Submission in Response to Proposed Pitt Street North Over Station Development (SSD 18_8875)

We act on behalf of the NSW Masonic Club, owners of 169-173 Castlereagh Street, Sydney in response to the proposed Pitt Street North Over Station Development (SSD 18_8875). The site subject to the proposed Over Station Development (OSD) is located on the adjoining southern boundary of the NSW Masonic Club. We have reviewed the exhibited documentation and are generally supportive of the proposal and understand the need for the Sydney Metro project and the associated OSDs. However, there are numerous issues identified in the design of the proposal and as such, the current design would generate significant amenity impacts to the existing Masonic Club and would result in a poor urban design outcome.

Figure 7: Planning Envelope Drawing - Podium Levels- Pitt St. North OSD. NSW Masonic Club outlined in blue. Pitt Street North OSD Concept Application. Appendix F-Built Form and Urban Design Report. Architectus 2018.

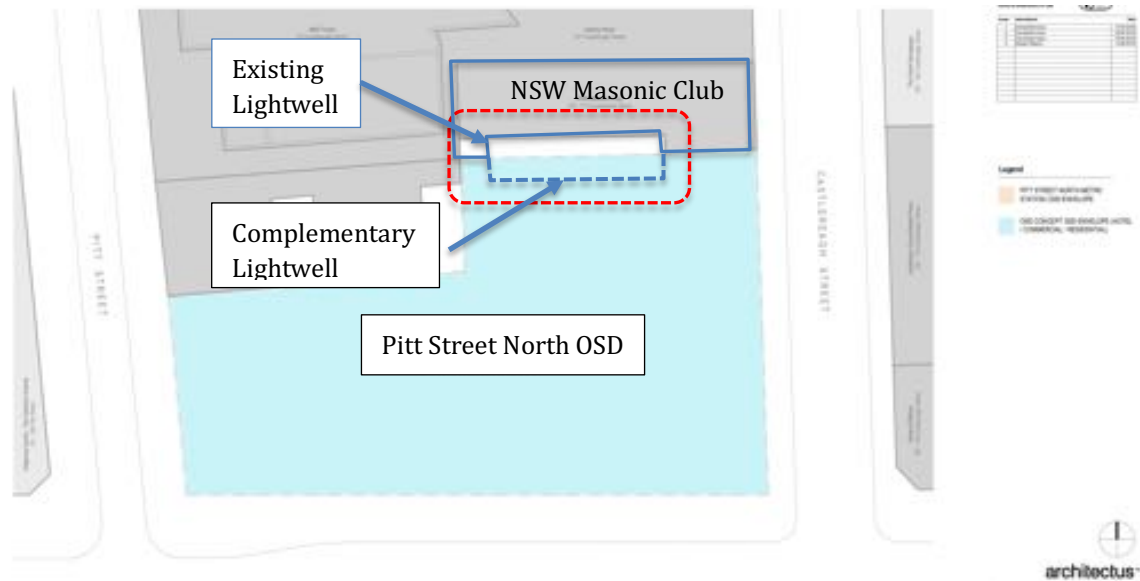
In the current proposal, there appears to be an attempt to provide some setbacks between the OSD and the NSW Masonic Club but at a higher level. This setback does not assist with improving light into the southern facing windows. The architectural plans provided indicate the proposed OSD will be built to the northern boundary up to the top of the NSW Masonic Club building when viewed from Castlereagh Street.

The current setbacks between levels 5 and 12 (Roof level) on the podium already exhibit a variation to the ADG separation criteria, although the club is prepared to maintain the proposed 7.6m building separation between the common boundary across the length of the southern facing windows. The proposed nexus of the façade of the buildings is generally acceptable from a streetscape and heritage perspective.

- Provision of a 7.6m building separation on the proposed ground level up to the podium terrace on level 12, consistent with the ADG design criteria. This should apply only to the central part of the building with a length of approximately 21m along the south facing windows.

Figure 12: Indicative Scheme Drawings – North South Section- Pitt St. North OSD. NSW Masonic Club indicated with blue outline. Pitt Street North OSD Concept Application. Appendix F-Built Form and Urban Design Report. Architectus 2018.

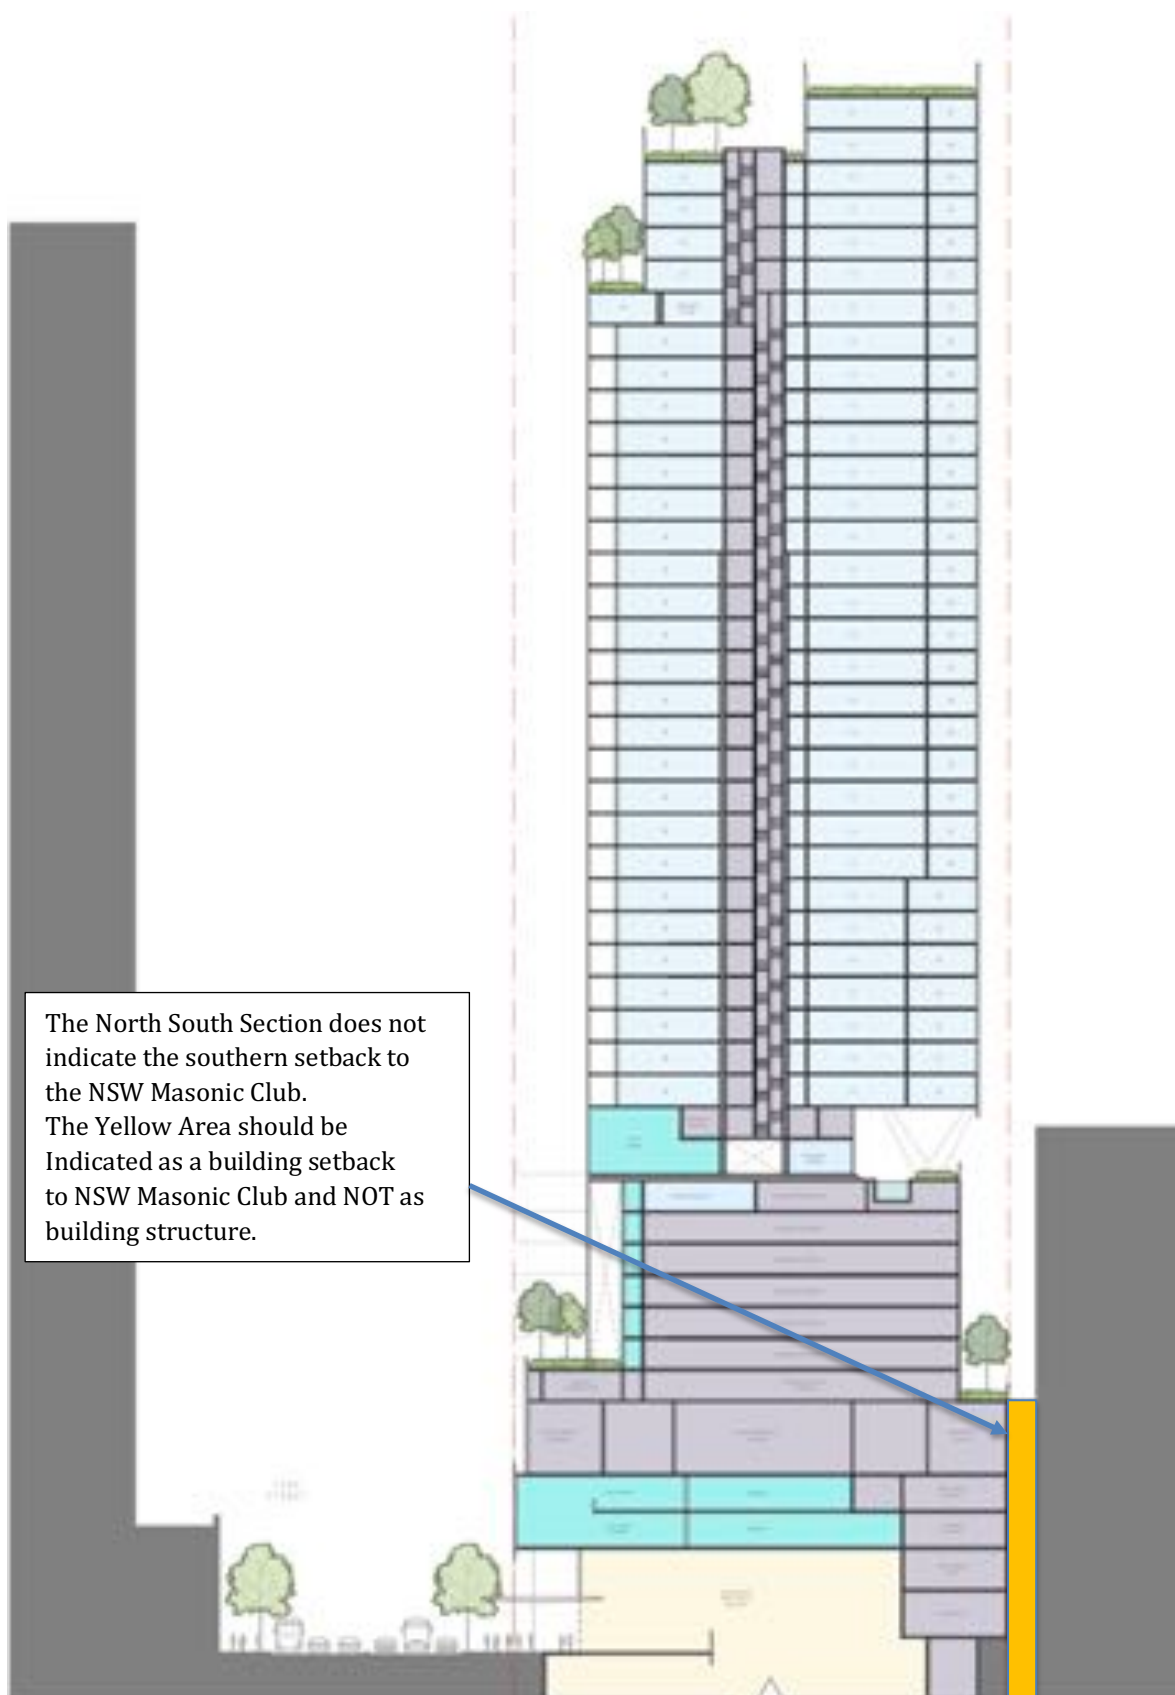
When examining the North-South Cross Section in more detail, Figure 11 below portrays our client's site as having a nil setback up to the fifth/top level of the proposed podium. It also does not show the corresponding uses of the floors of the NSW Masonic Club. As demonstrated in Figures 9 and 10 above, this is not the case as the setback extends down to the basement level of the building. Consequently, the section provided is inaccurate and does not present a true representation of how the proposed OSD interacts with the southern elevation of the NSW Masonic Club.

According to our measurements, the existing setback between the southern alcoves of the NSW Masonic Club and the southern boundary is approximately 1.6m. From windows associated with the hotel on levels 6 and above, the setback is approximately 2.6m. On the proposed level 5 of the OSD, there is an approximate 5m setback to the northern boundary. As such, there is a maximum building separation of approximately 7.6m between the two buildings.

The current design provides a setback of approximately 5m to the northern boundary from podium level 5 up to level 12. The existing building setback between the NSW Masonic Club and the southern windows associated with the hotel is approximately 2.6m. Subsequently, the total building separation will be 7.6m, considered to be a suitable distance to achieve improved amenity for the Cellos Grand Dining Room and above hotel rooms. The minor encroachment recommended to the current building envelope is insignificant in relation to the site's size of 3,151sqm and overall scale of the 43 storey development.

As discussed above, there will be a nil setback to the northern boundary from the ground level up to podium level 5. The proposed development incorporates five levels of car parking corresponding to the hotel rooms of the NSW Masonic Club/Castlereagh Boutique Hotel. The outdoor area associated with the podium level is in line with the top two levels of the hotel rooms. We understand the intention of this outdoor area is to provide amenity for the future residents/hotel guests, although further details are required to be provided demonstrating the potential overlooking impacts between the proposed building and the NSW Masonic Club. Details such as privacy screens and landscaping should be incorporated in any future application to allow our clients the opportunity to ascertain whether the privacy of the hotel guests can be preserved.
